July 14, 2020

**RE: Woodmen Hills Metropolitan District
West Concrete Water Storage Tanks
Site Development Plan (PPR-20-0017) – Comment Response Letter**

**DP3**  
 SHEET 3 OF 4

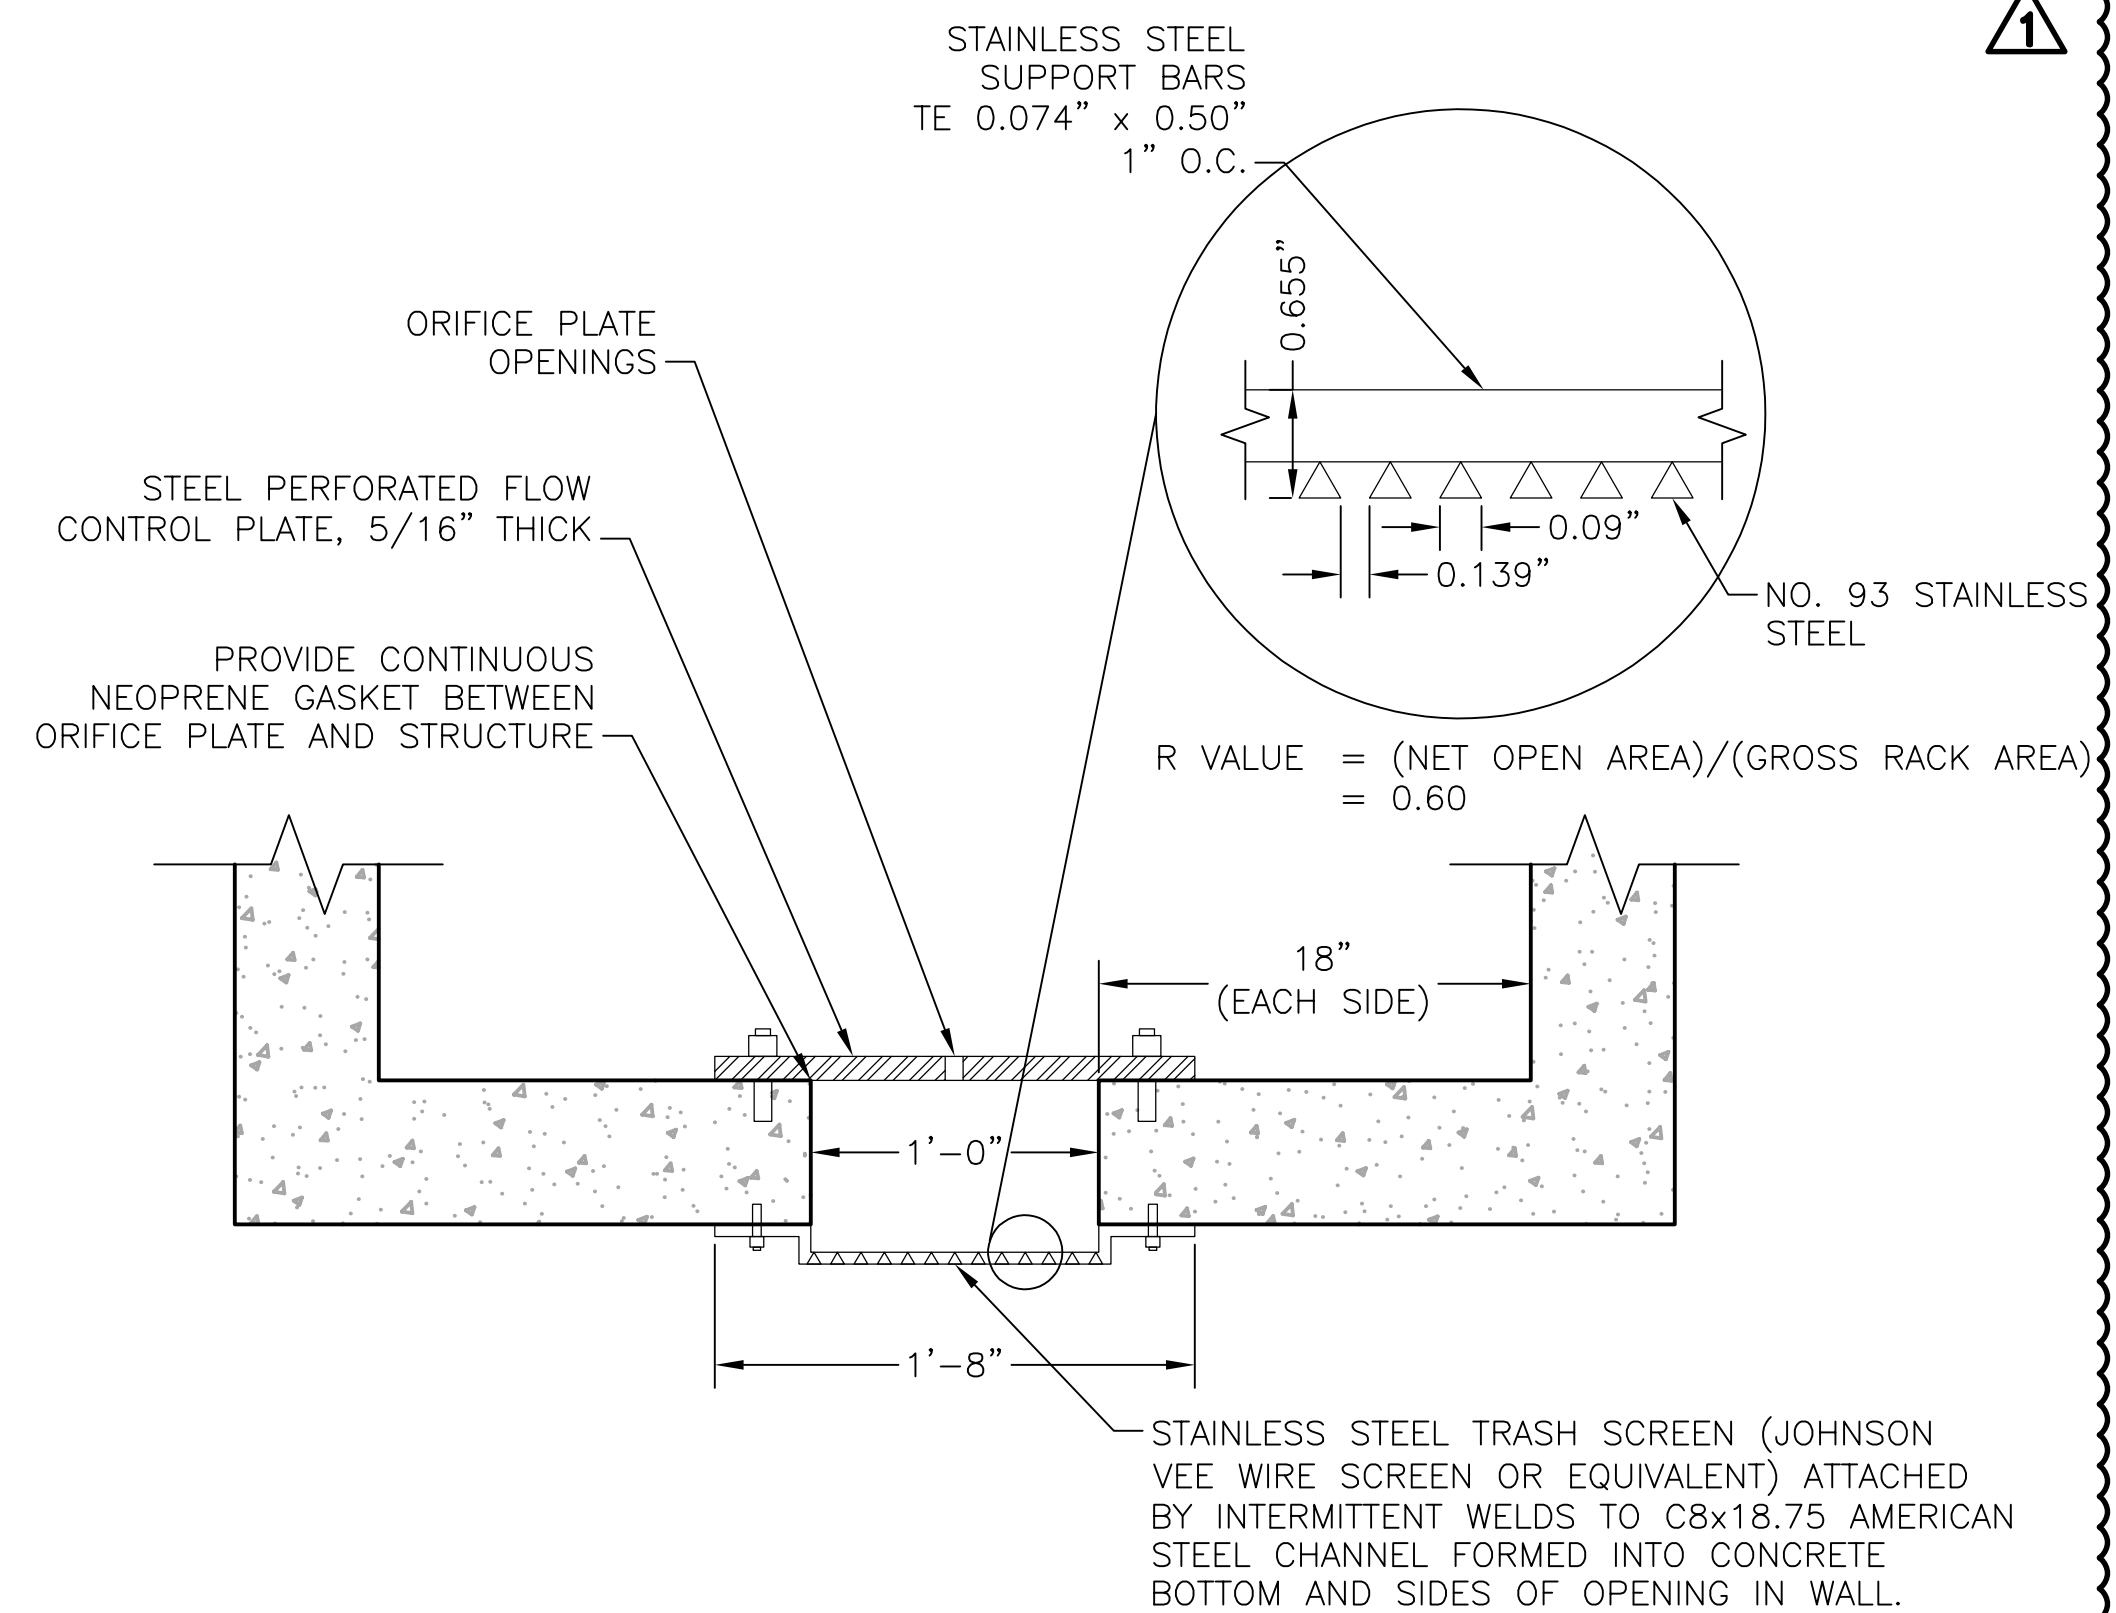
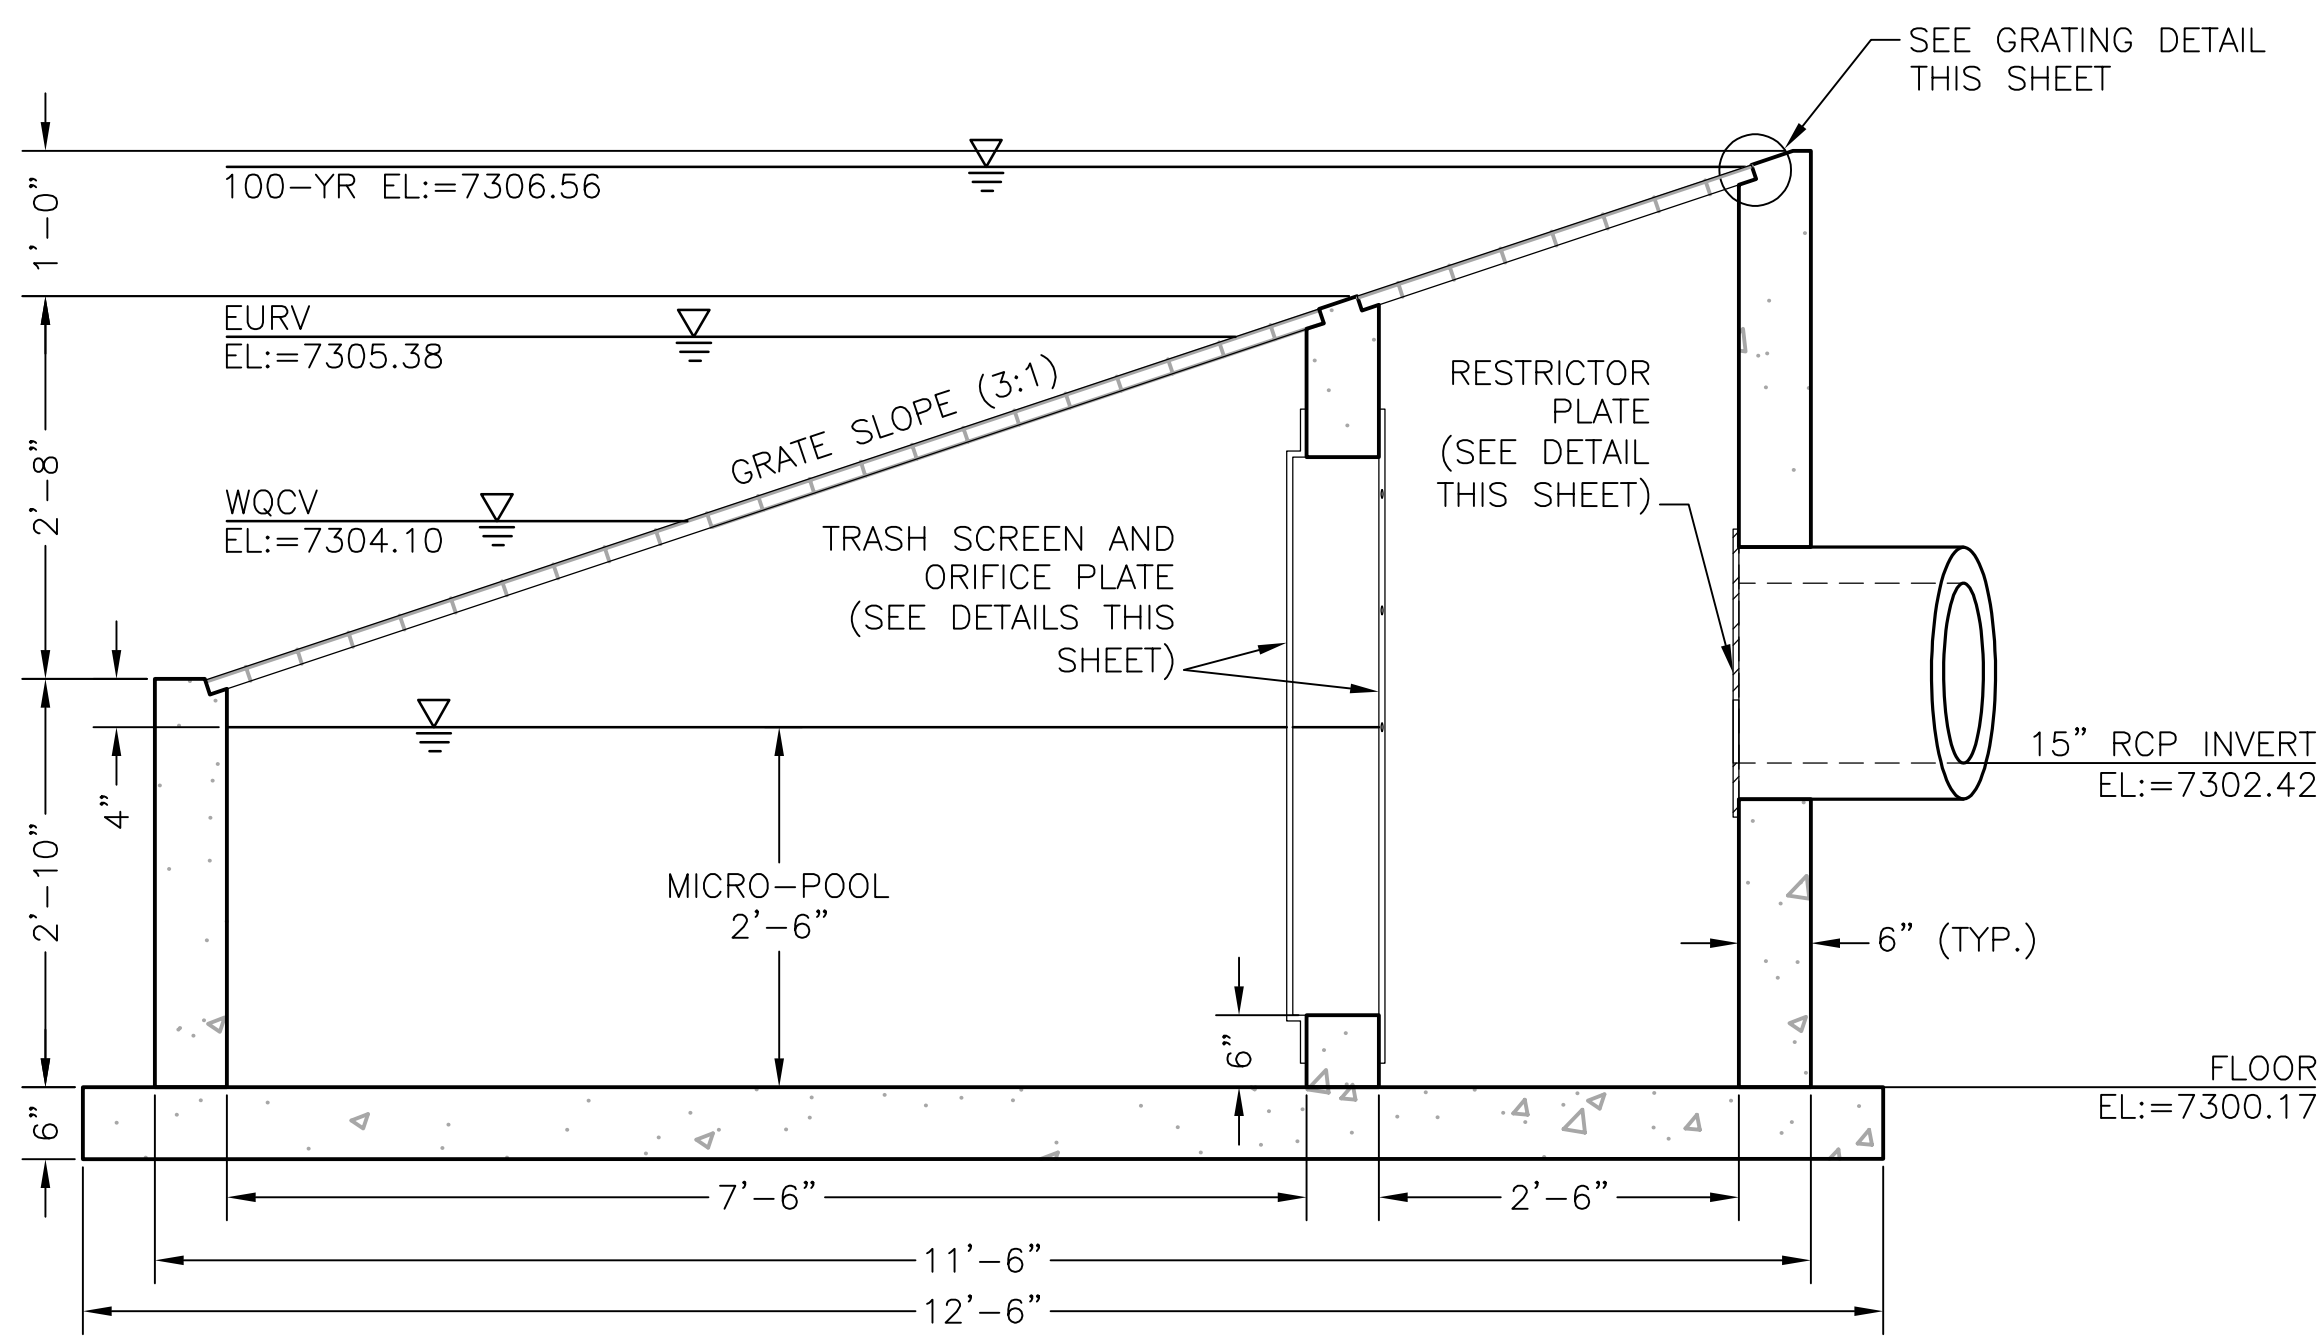
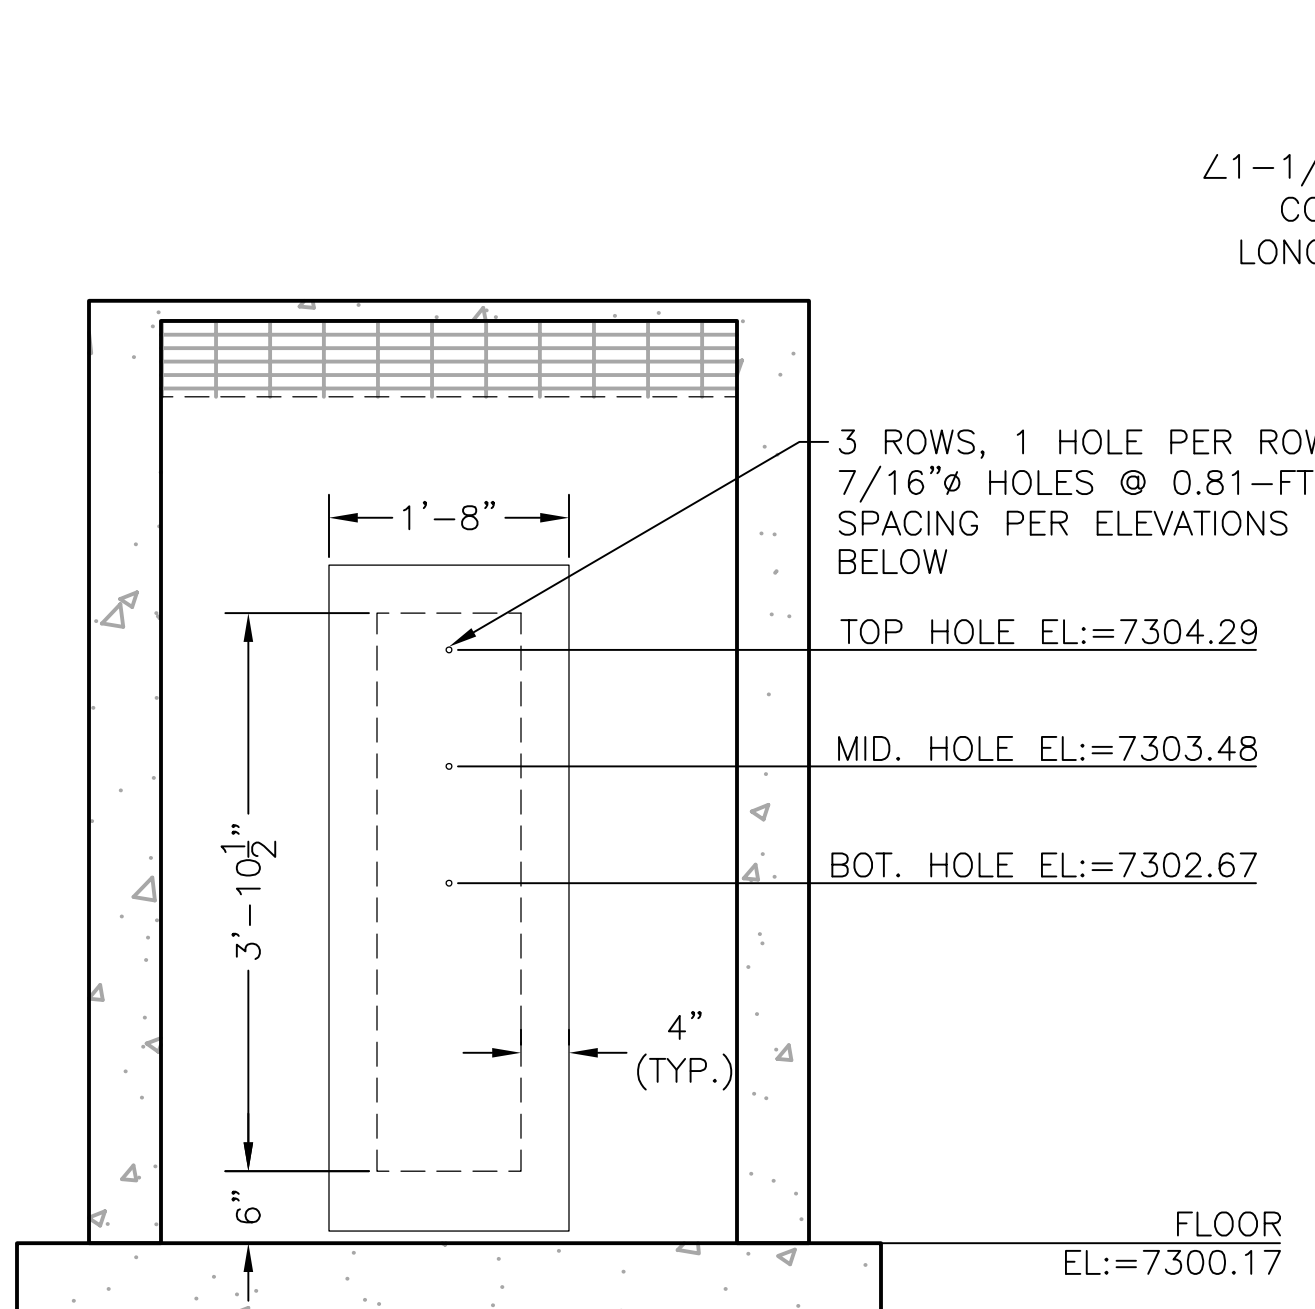
14. Appendix F, DP3: See revision to ECM adopted July 2, 2019. Outlet structure must comply to the details shown in that revision (UDFCD Nov 2015) design.

Outlet structure revised to comply with the details in the UDFCD November 2015 design. Revised drainage sheets are included in Appendix F.
